ENG-SF19004-R4-FDR-Redlines. Summary_Markup Summary

ENG-SF19004-R4-SC-CDs-Redlines Summary_Markup Summary

**HOMESTEAD AT STERLING RANCH FILING NO. 2**  
GRADING PLAN  
DATE: 03-03-2020  
PROJECT NO. 09-007  
SCALE: HORIZONTAL: 1"=50' VERTICAL: N/A  
DESIGNED BY: DLM  
DRAWN BY: JWP  
CHECKED BY: VAS

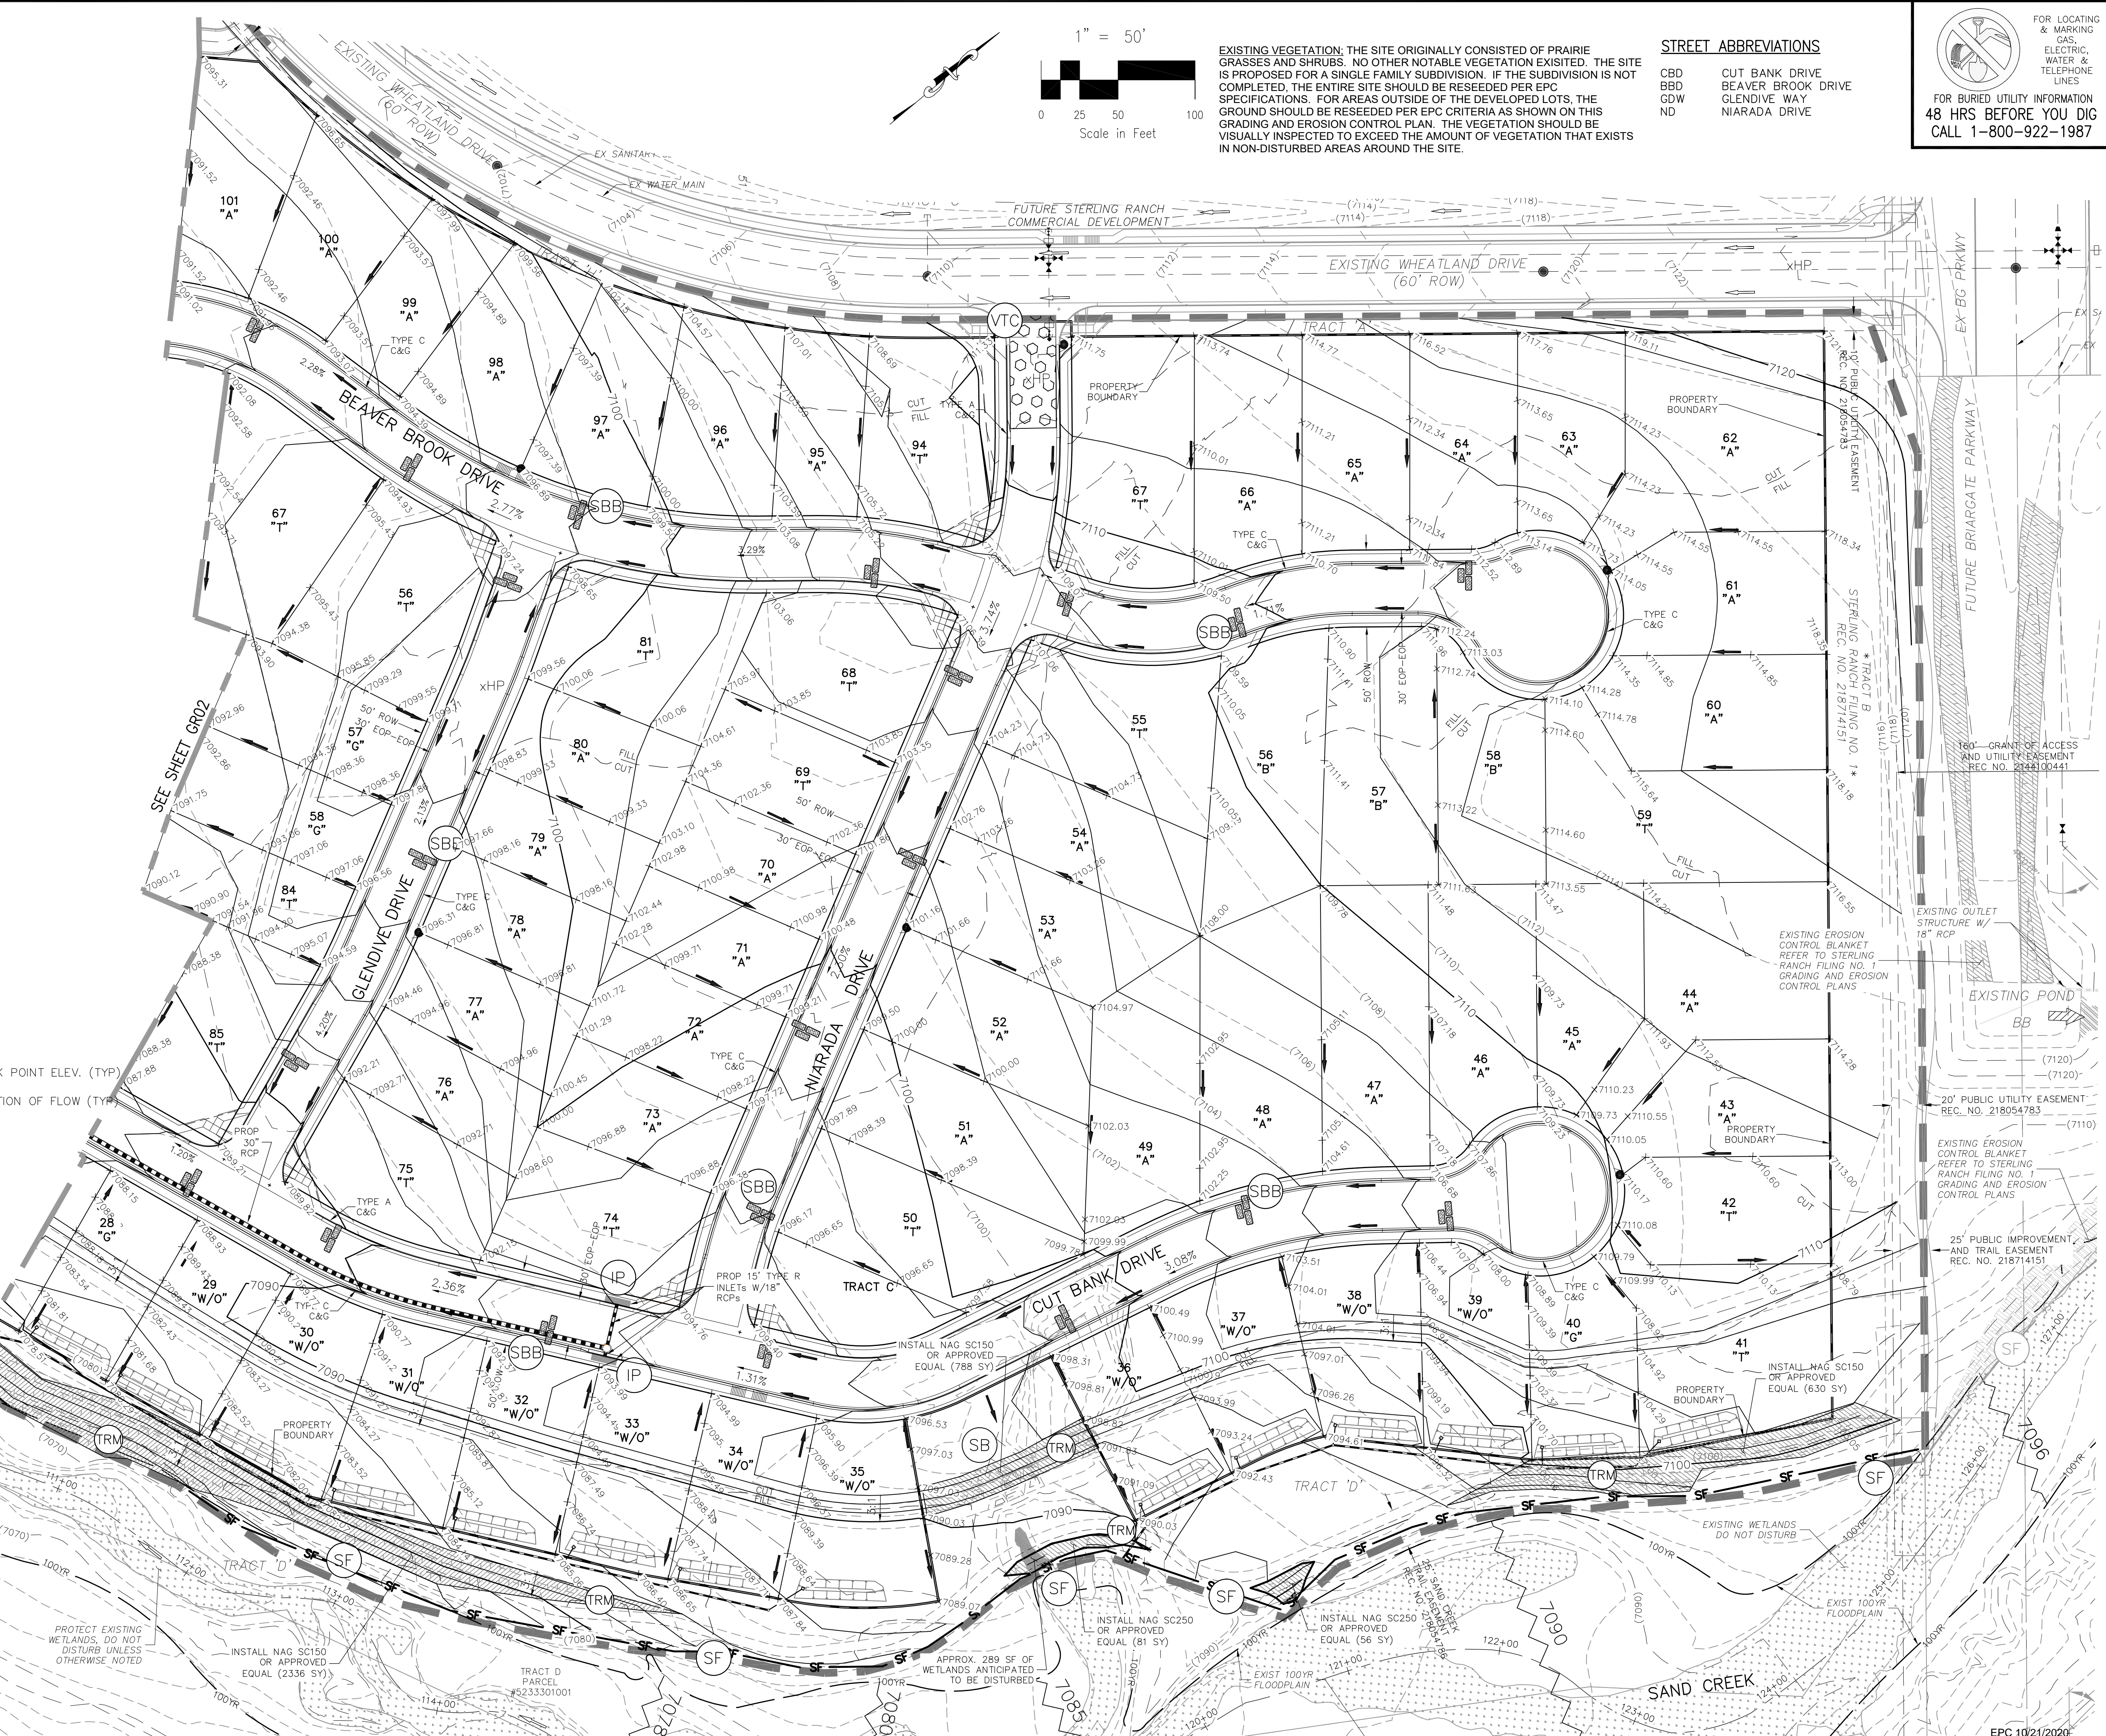
Show in legend Trail designation.

Show velocity and Froude number for sections SL-185, SL-184, SL-183

Call out for Pond 4?

Show the bench for the trail.

Emergency spillway constructed with ? Plans, call out.

PROPOSED DRAINAGE MAP

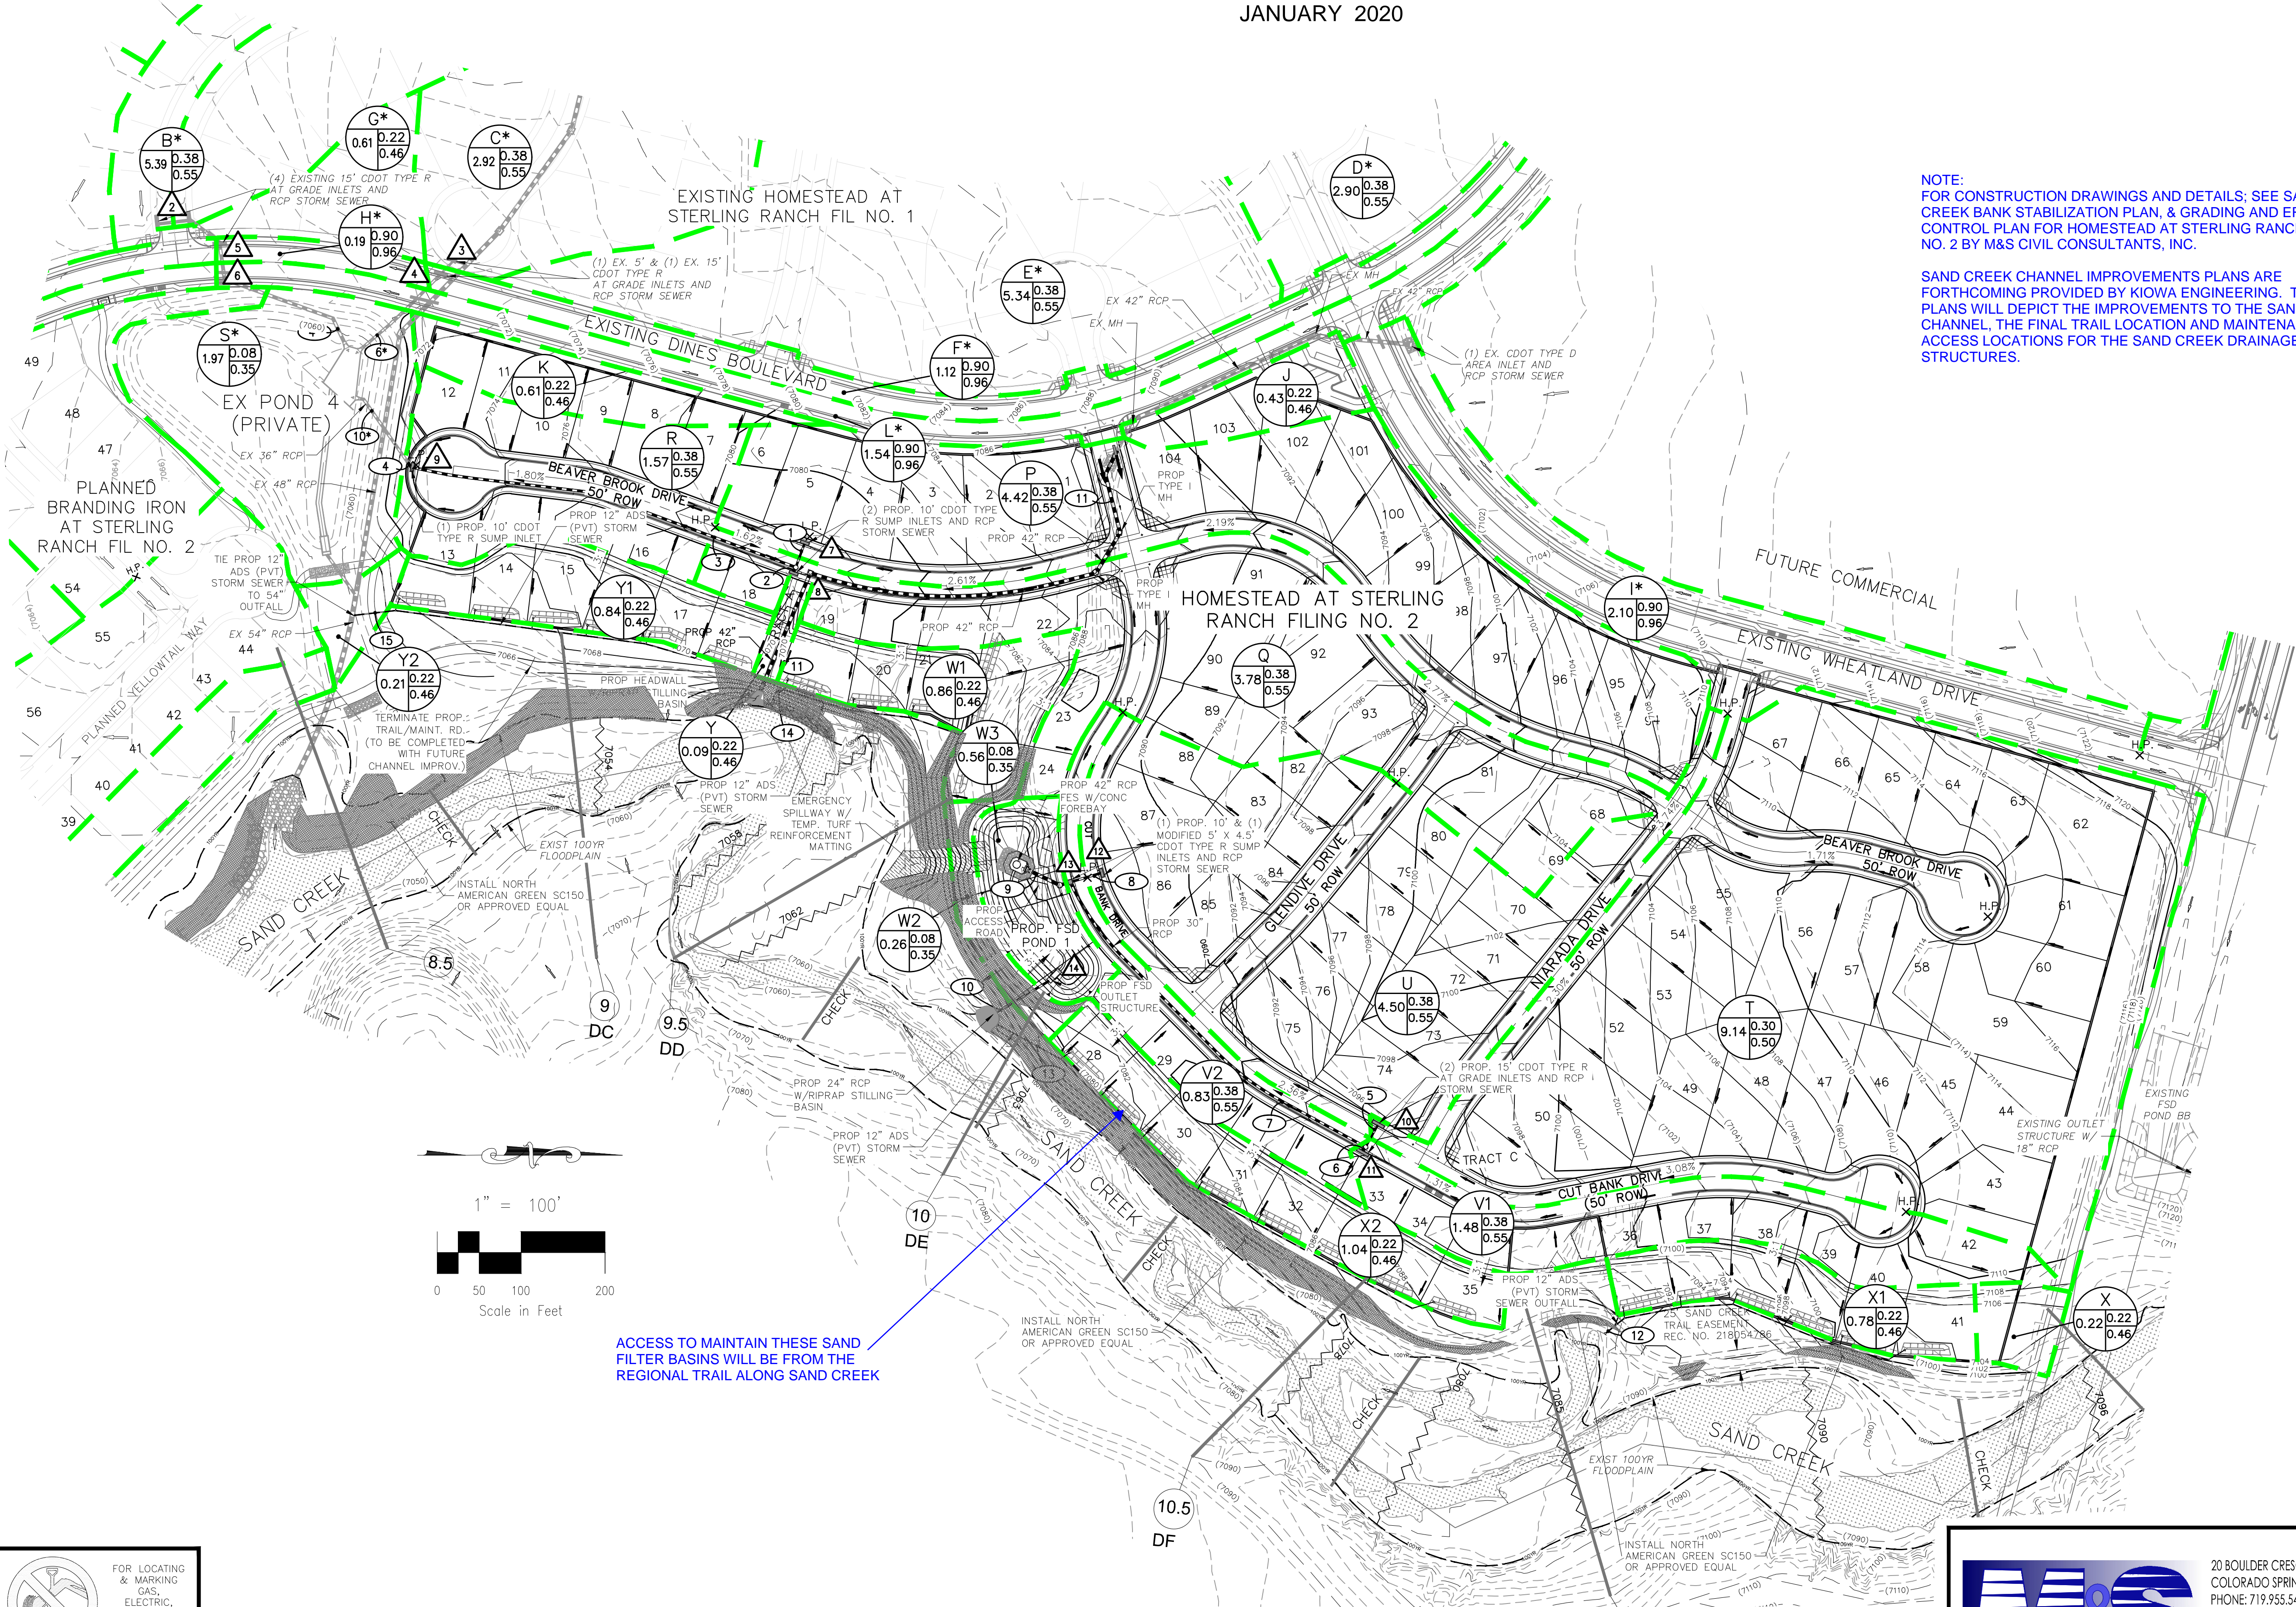
Indicate where the access
to these individual SFB's
will be provided. etc.

Will the trail be utilized to access and maintain the SFBs?
